**HUDDERSFIELD**

**CIVIC**

**SOCIETY**

## **KIRKLEES CULTURAL HEART (KCH) - PLANNING APPLICATION (2022/93248)**

THE GREEN

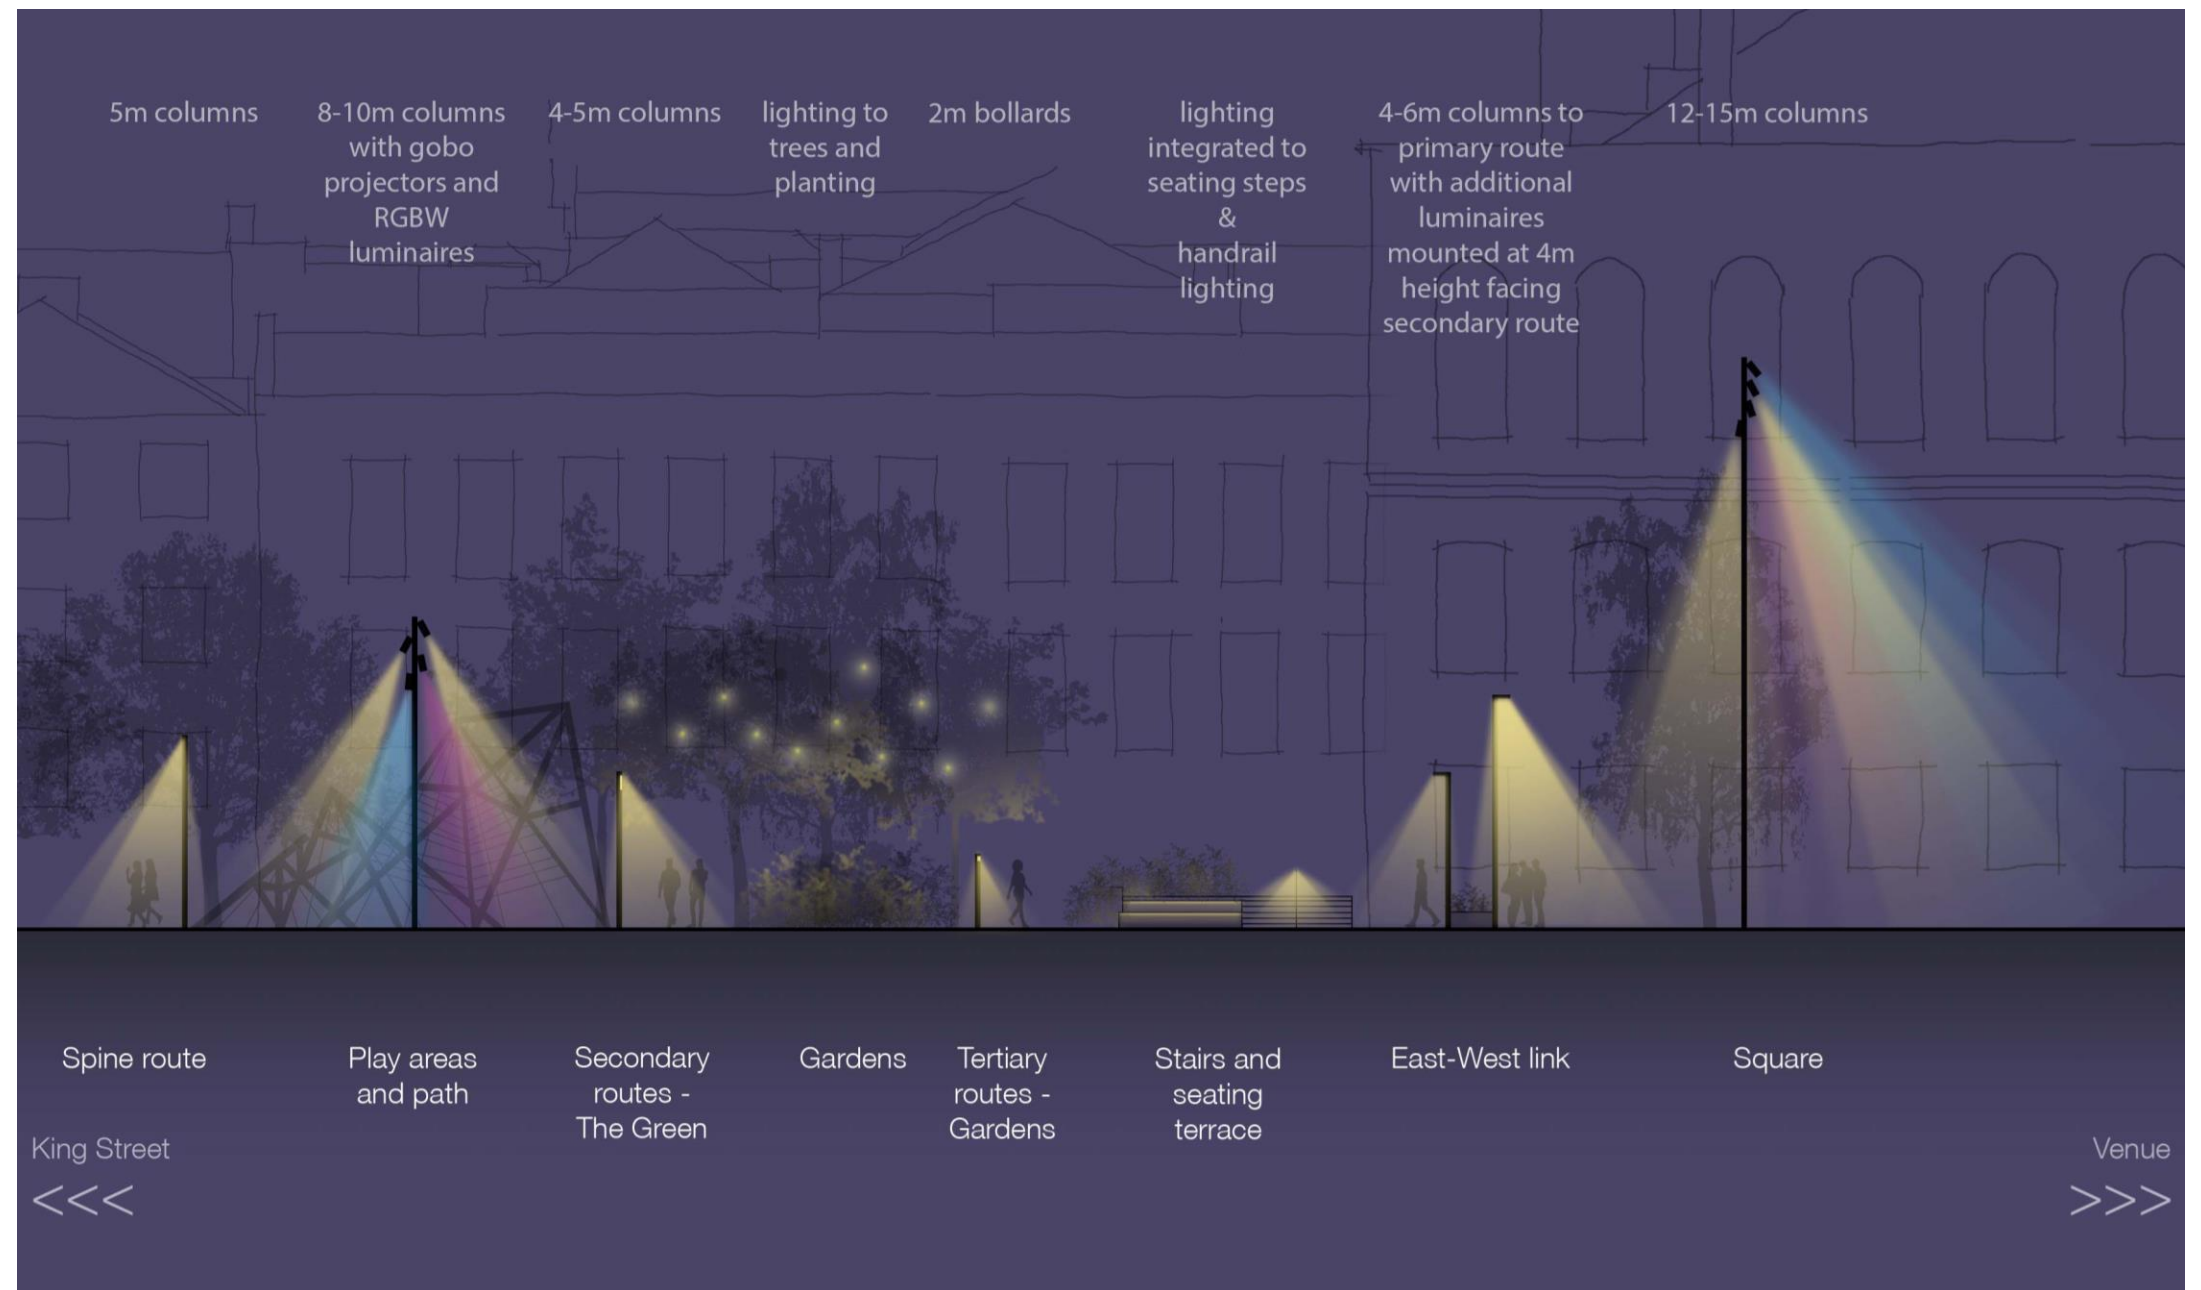
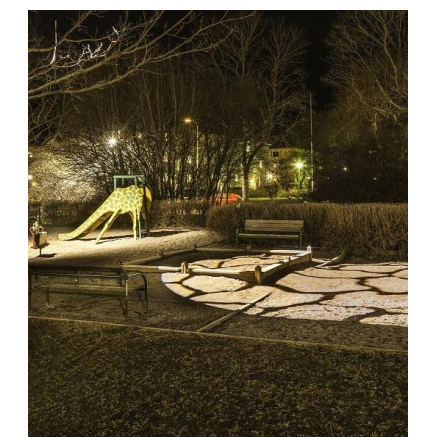
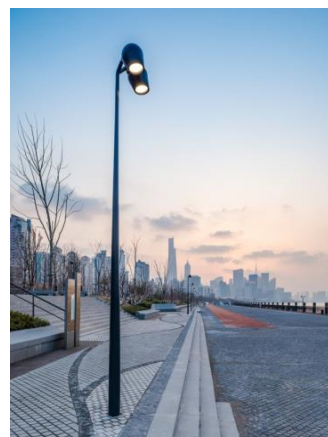
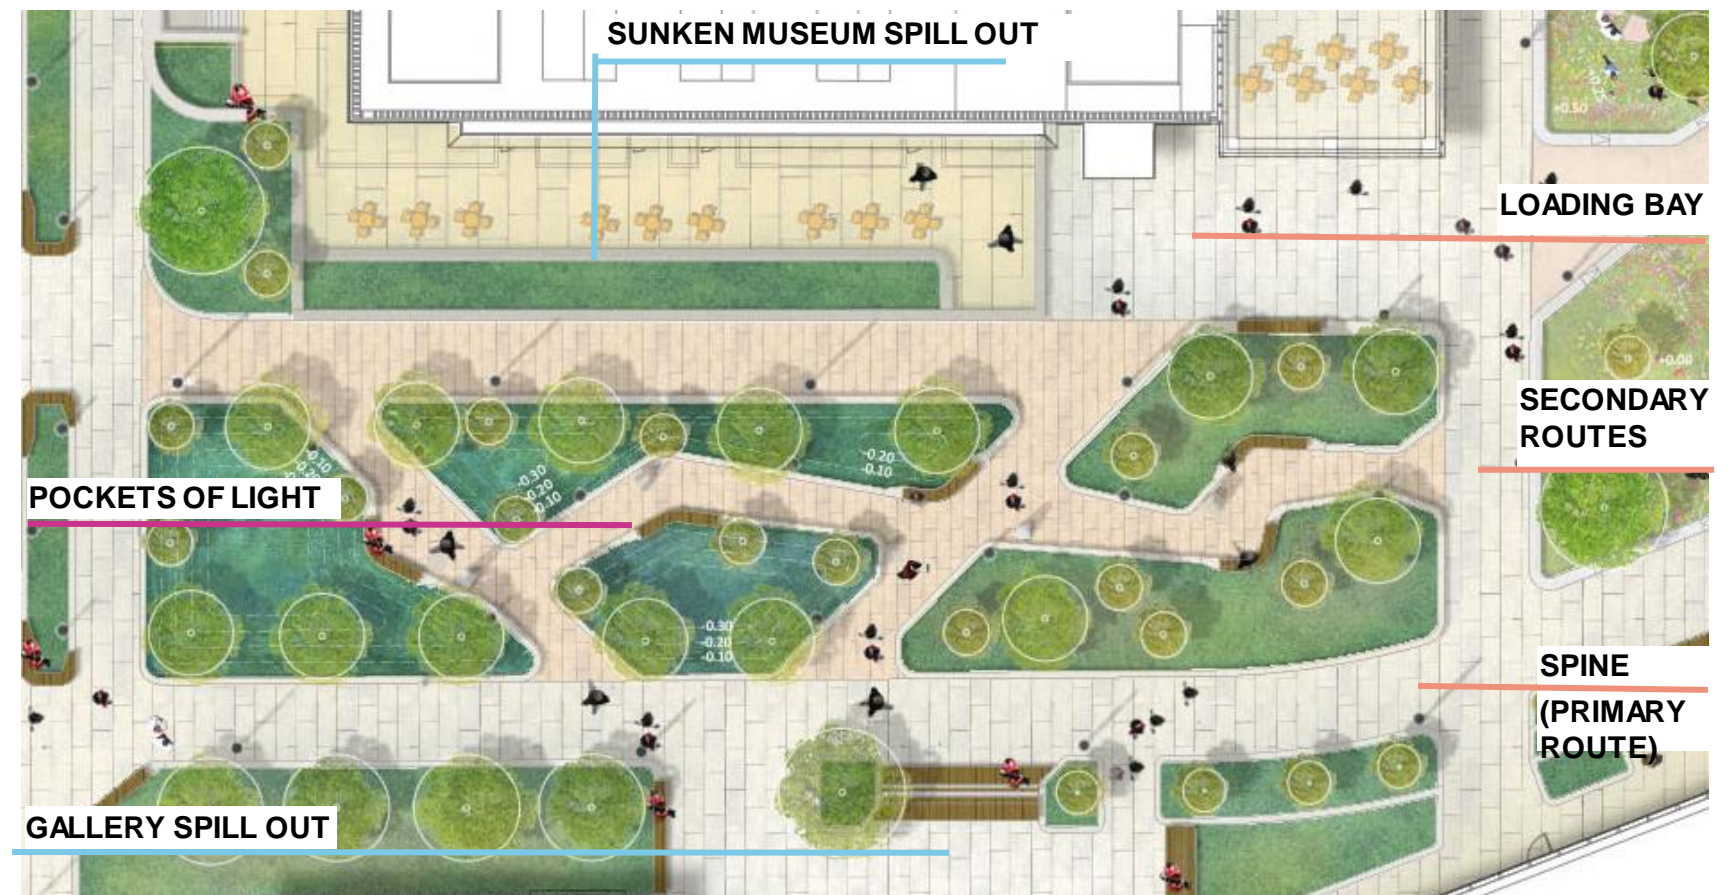
The provision of a 'skate wall' alongside a pedestrian route appears ill advised. This type of activity requires a large, segregated area available (for instance in the skatepark at Greenhead Park). The proposed small-scale linear provision, within a busy pedestrian area, is likely to fail to attract many skaters. Where it does, skateboarders will introduce health and safety risks for themselves and seated/mobile pedestrians (including small children, the elderly, and people with disabilities). There will also be the associated noise and risk of graffiti in this area, as often the case in skateboarding areas. How will the wall be protected against graffiti and other damage from skateboards?

**HCS Strong Objection:** This feature should be eliminated from the scheme design.

1 Proposed Elevation North
1 : 200

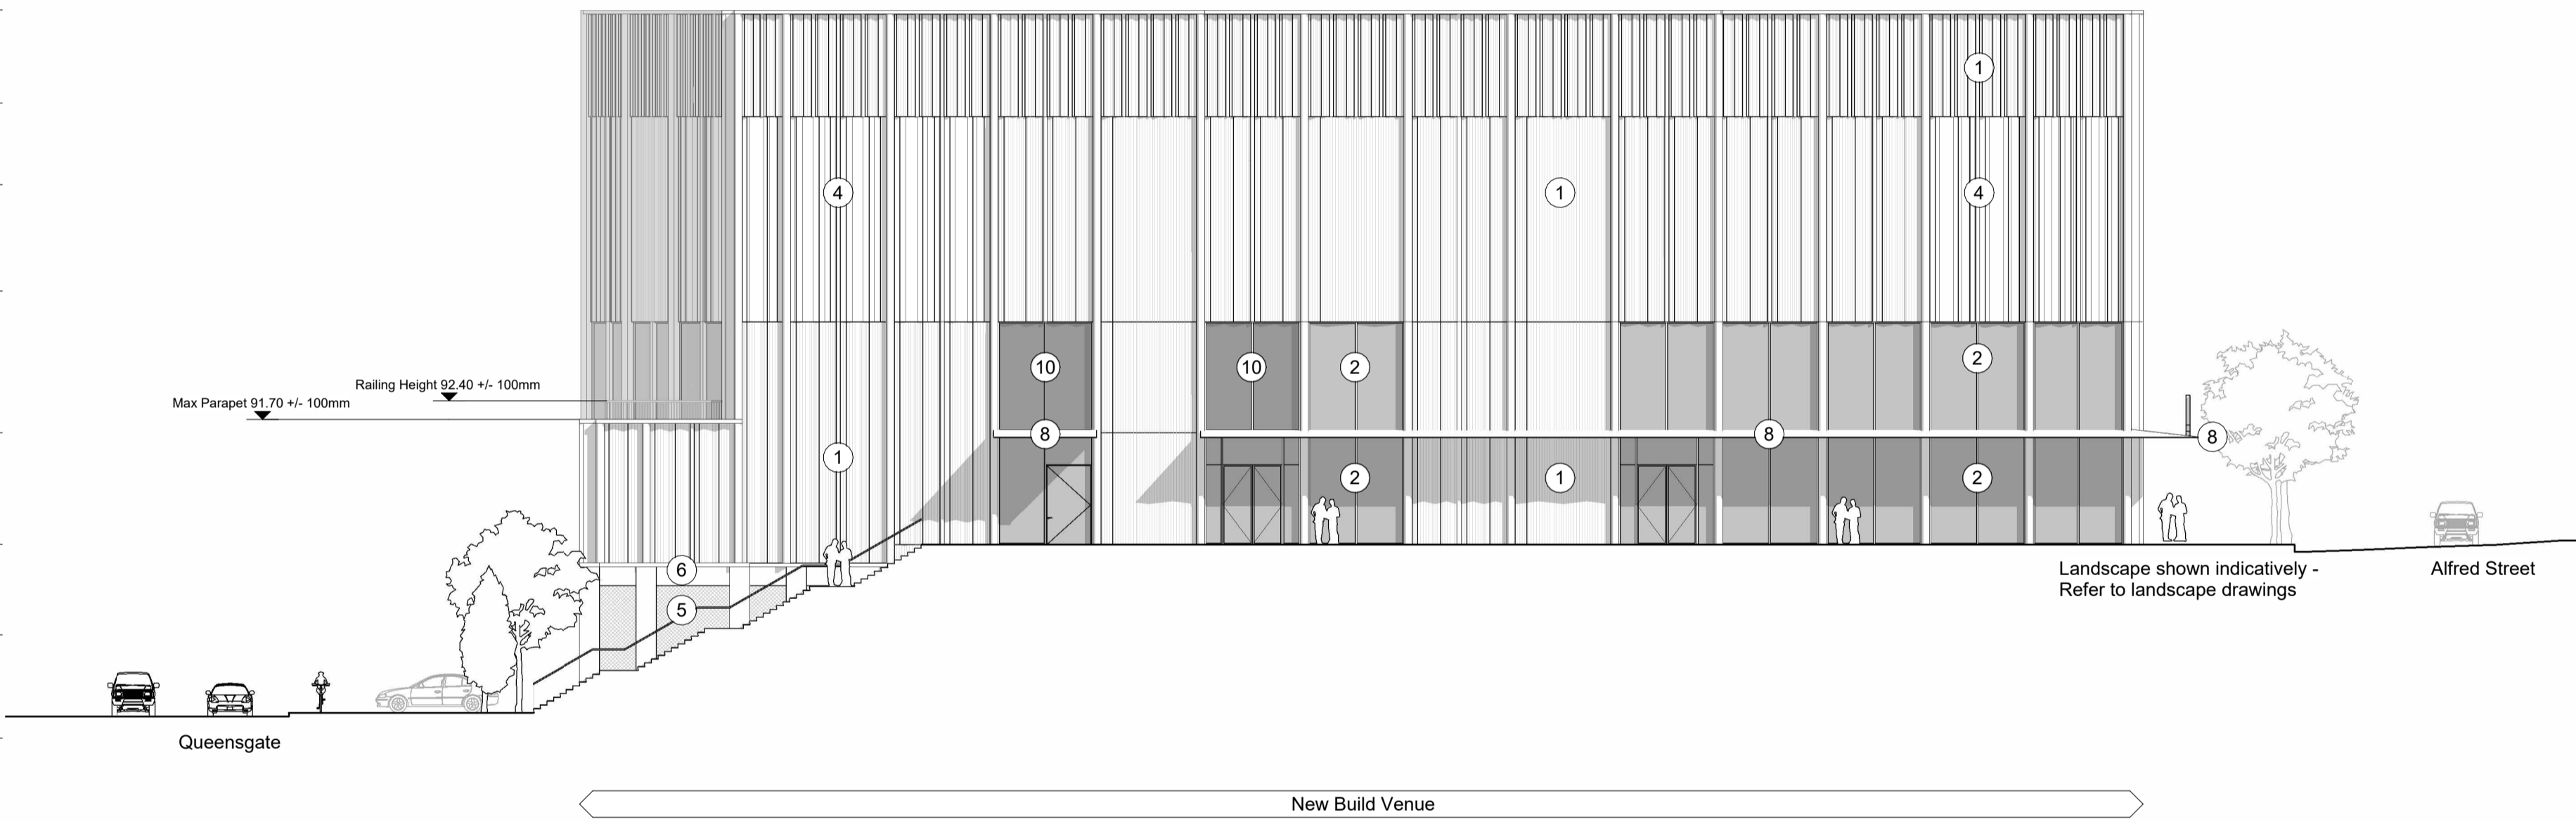
Whilst HCS recognise the challenge in incorporating a large events venue and car park into one building, there remain concerns regarding its monolithic appearance in relation to views from further afield (say from the direction of Castle Hill), and in relationship to St. Paul's and the Ramsden Buildings on the University Campus. Elevations, although incorporating pleats, ribbing, folds and other devices remain somewhat bland.

**HCS Comment: The use of ceramic facings may provide a means to enliven what might otherwise come over as 'corporate beige', as would incorporation of public art (see point 2.4 below). Concern remains about the longevity of the 'subdued perforated metal' on the ground floor area of the car park onto Queensgate.**
